From: Sue Howell <Sue.Howell@arun.gov.uk>
Sent: 16 January 2020 14:45
To: Planning.Responses <Planning.Responses@arun.gov.uk>
Cc: Simon Davis <Simon.Davis@arun.gov.uk>
Subject: RE: Planning Consultation on: BE/109/19/OUT

Comment from Greenspace

APPLICATION NO: BE/109/19/OUT

Site Address: Land east of Shripney Road & south of Haddan House Shripney
Road Bersted PO22 9NW

DWG NO. :	DLA.1948.L06.	REV : S08
-----------	---------------	-----------

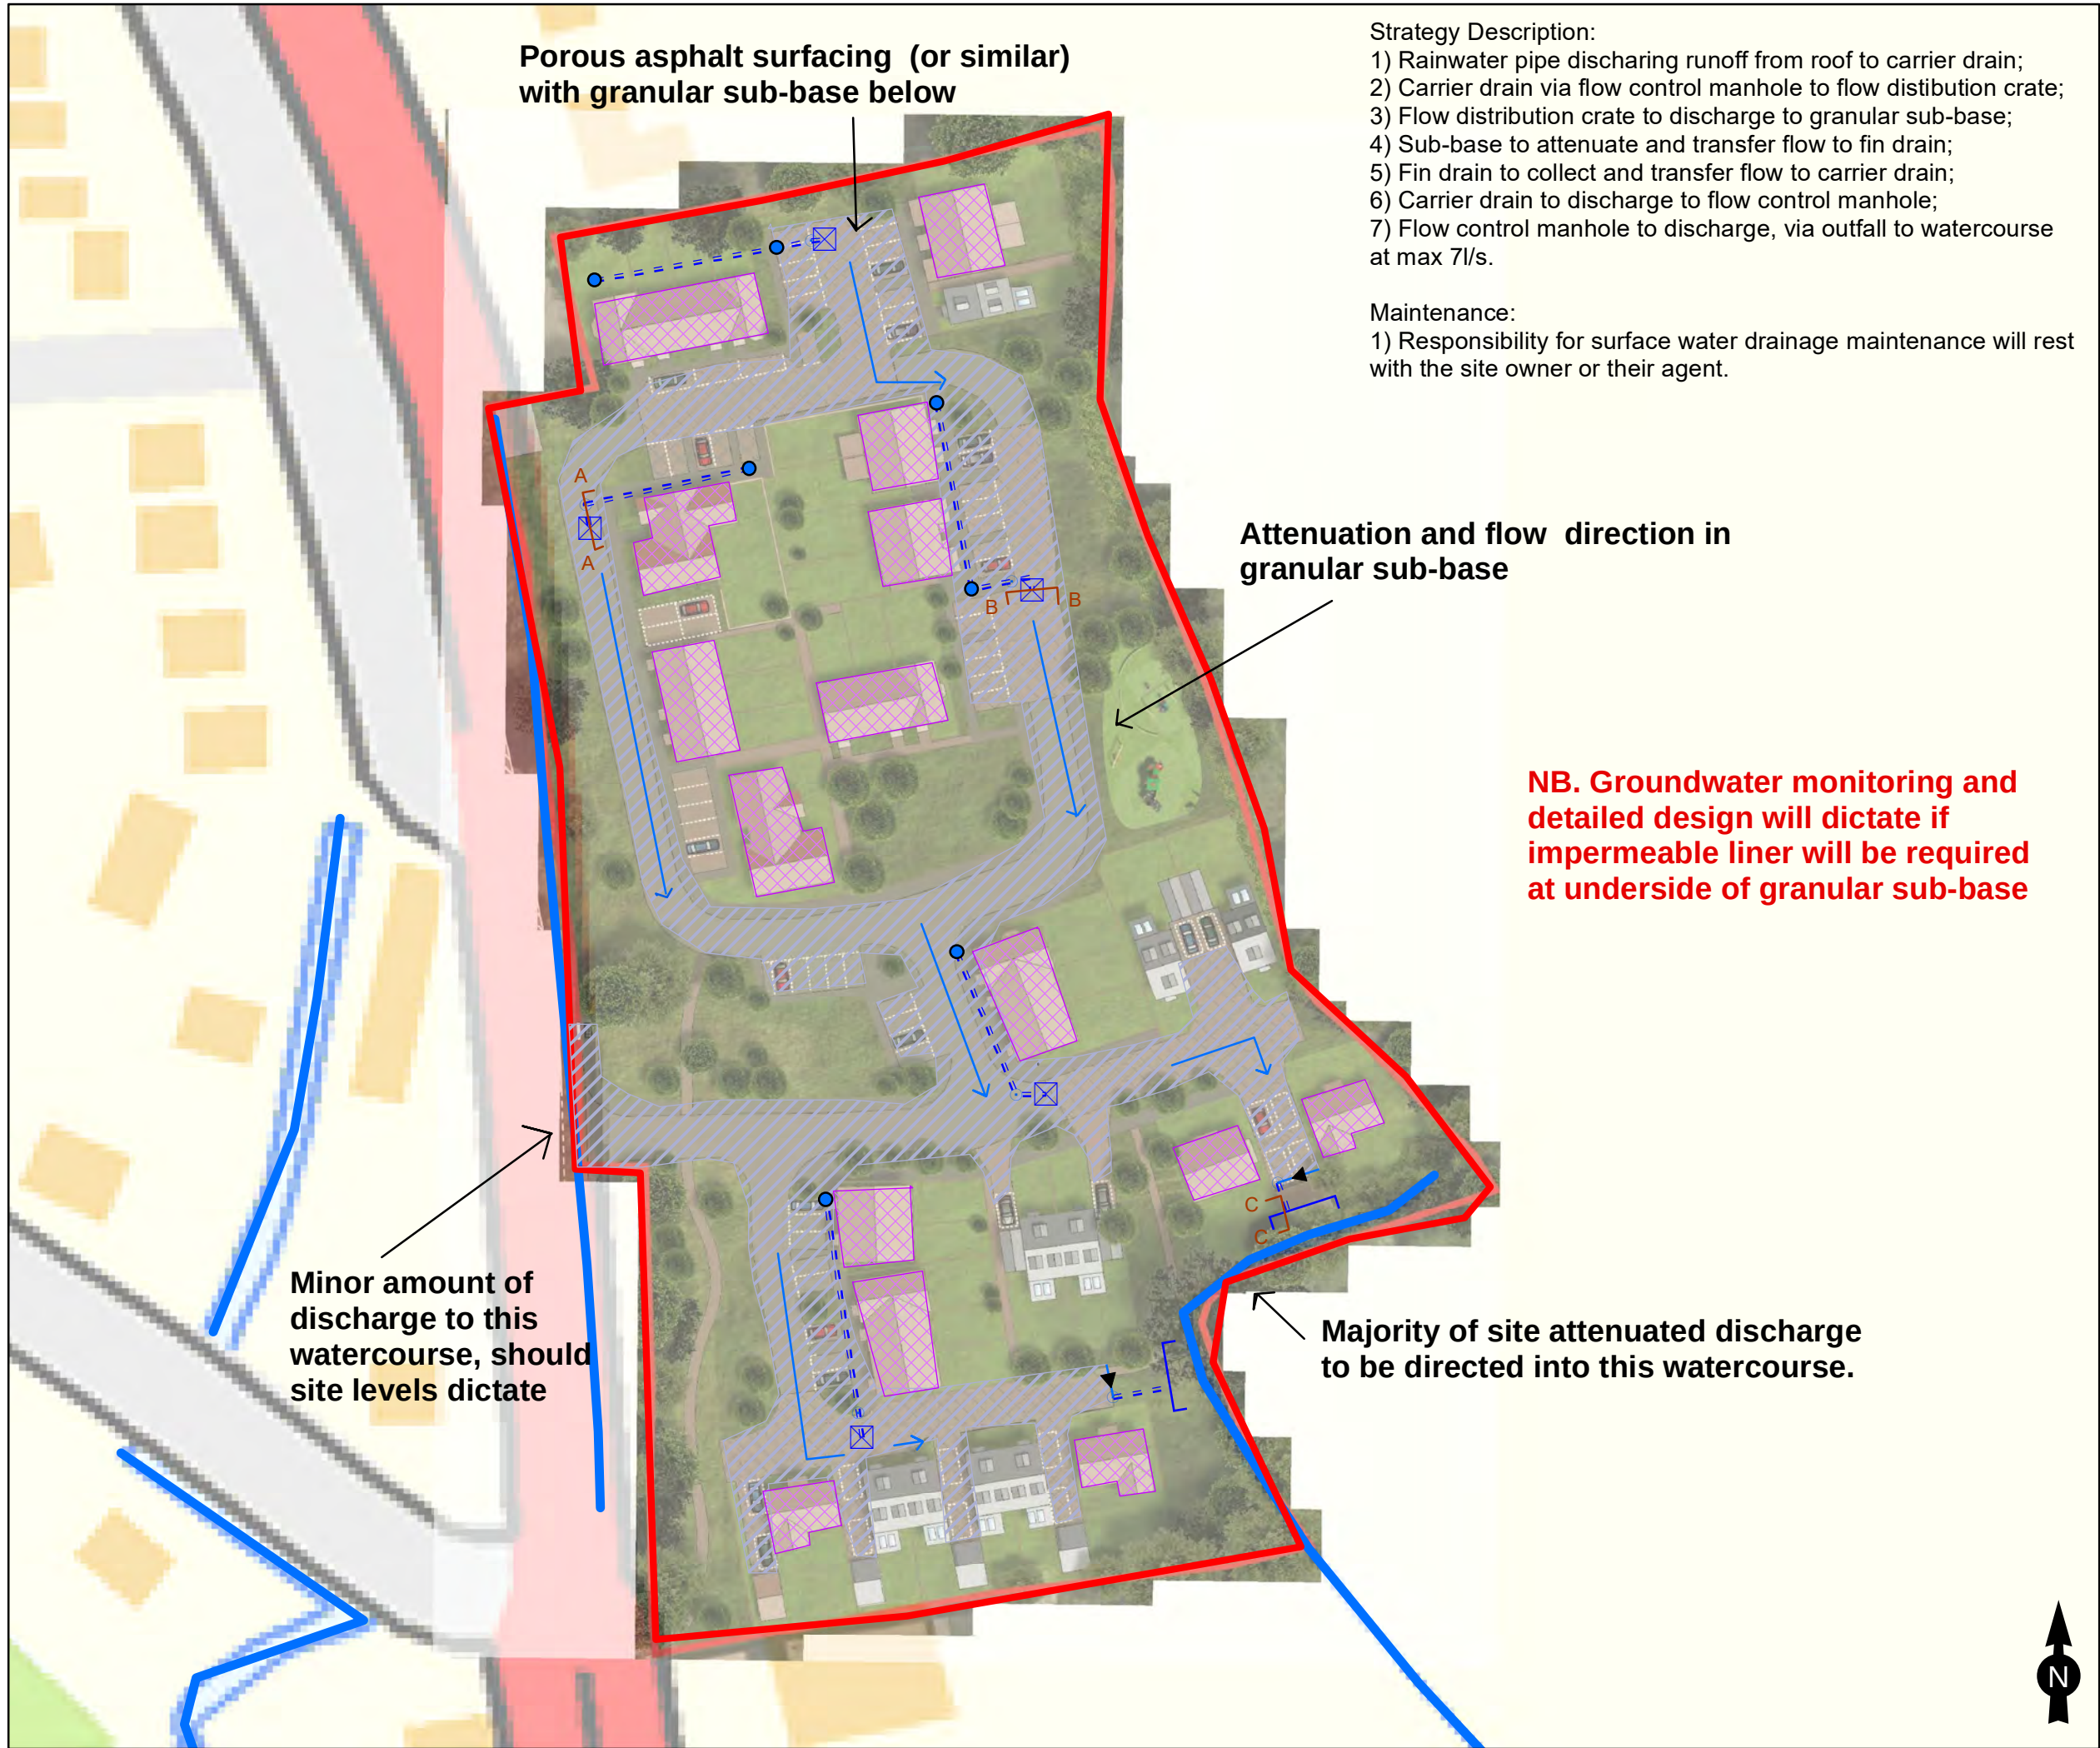
This development will require the inclusion of landscaping to soften and screen the development and allow it to fit within the environment. The landscaping should be such that it encourages biodiversity enhancement and encourages habitat formation with a mix of native and ornamental species, evergreen and deciduous to allow all year round interest. A full landscape scheme should therefore be submitted for approval, detailing species choice, position, actual quantities, densities and size at time of planting. This should be plotted in plan and list form and in relation to the trees and vegetation to be retained so that a clear picture of the proposals can be seen. These details are required to assure the adjacent properties privacy is maintained, screening is to be provided where required and the setting is uncompromised. The illustrative masterplan DLA.1948.I.07.PO4 only shows indicative proposals at this stage.
